PLANNING CONSULTATION RESPONSE

Application No	2026/0002
Proposal	Development of supported living for three single storey one bedroom bungalows and communal staff facilities with associated landscaping, access, and parking
Address	Land to the south of Castle Lane, Penistone, Barnsley
Date of Consultation Reply	04/02/26
Consultee	Highways Development Control

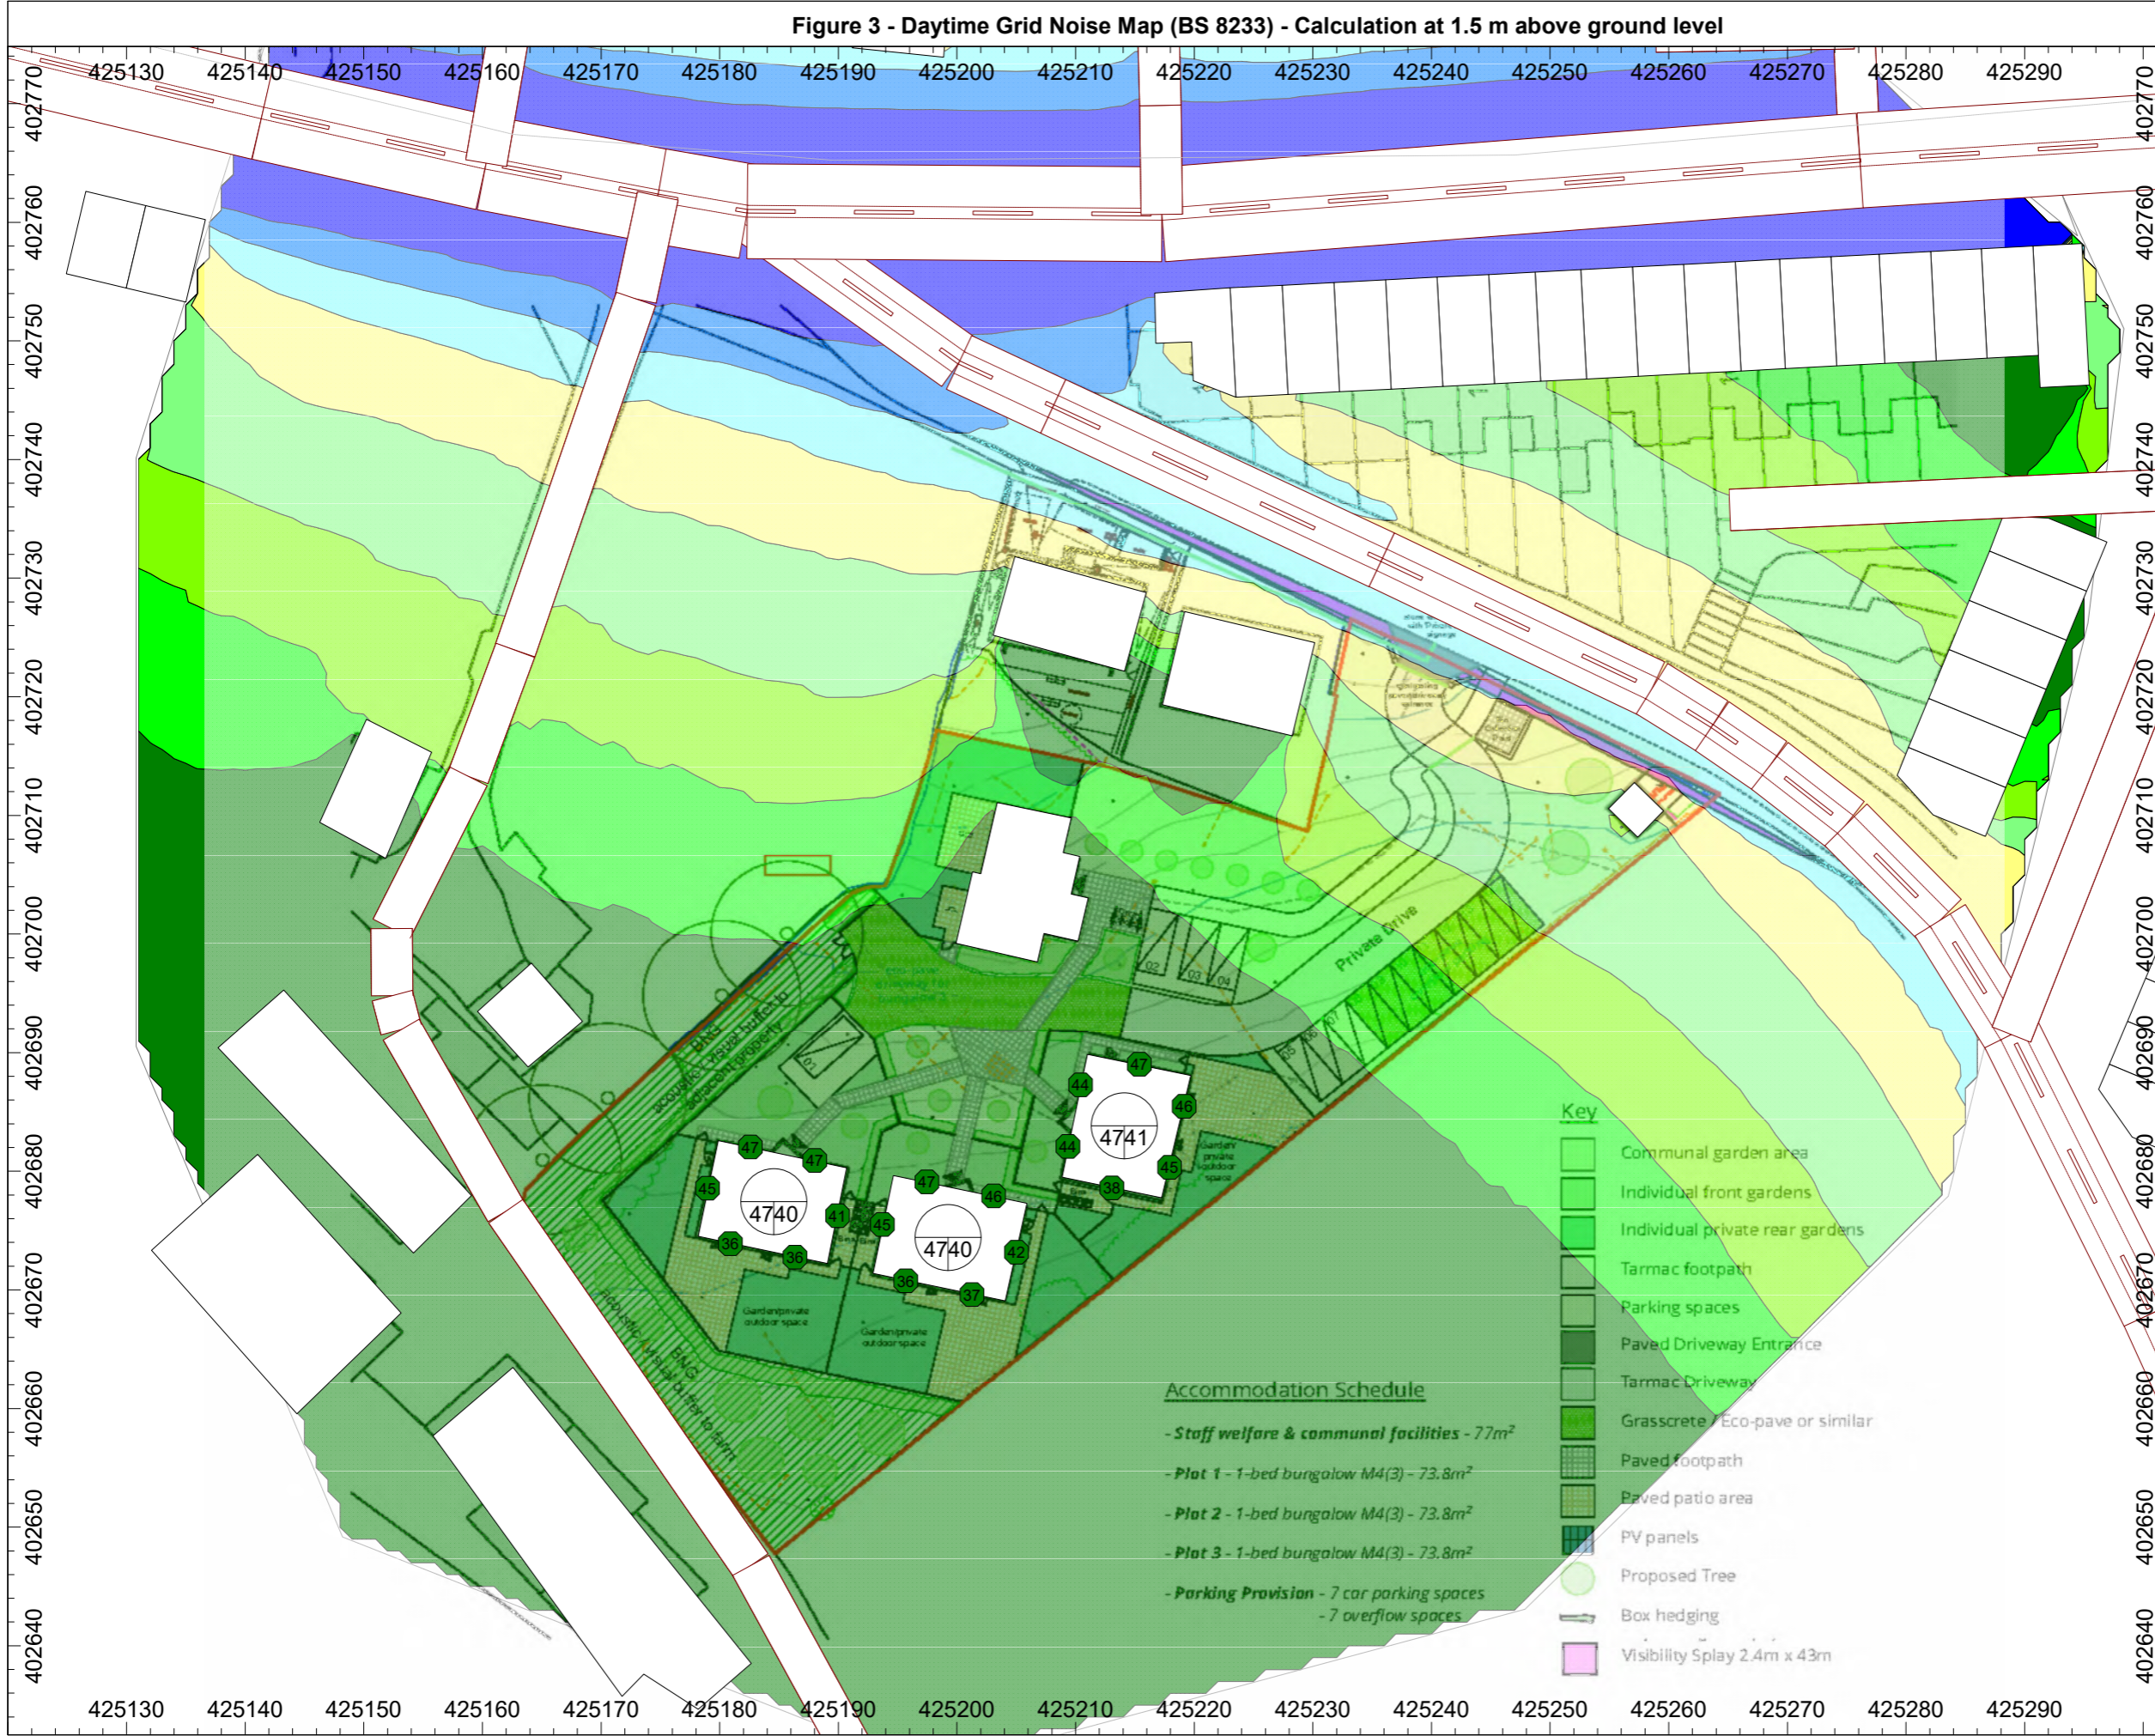
Vehicular access to the development is proposed via a shared private drive taken from Castle Lane. This access will need to achieve vehicular visibility splays of 2.4m x 43m and the lack of pedestrian provision will need to be addressed. At this stage, there are concerns that the visibility splays may not be achievable within existing site constraints, and this issue remains central to the acceptability of the proposed access arrangement.

Highways Development Control has been contacted directly by the applicant's transport consultant to discuss these visibility constraints. We understand that speed surveys have been carried out and amended layout plans are being prepared to address the issues in relation to the vehicular access. We therefore expect revised drawings to be submitted in due
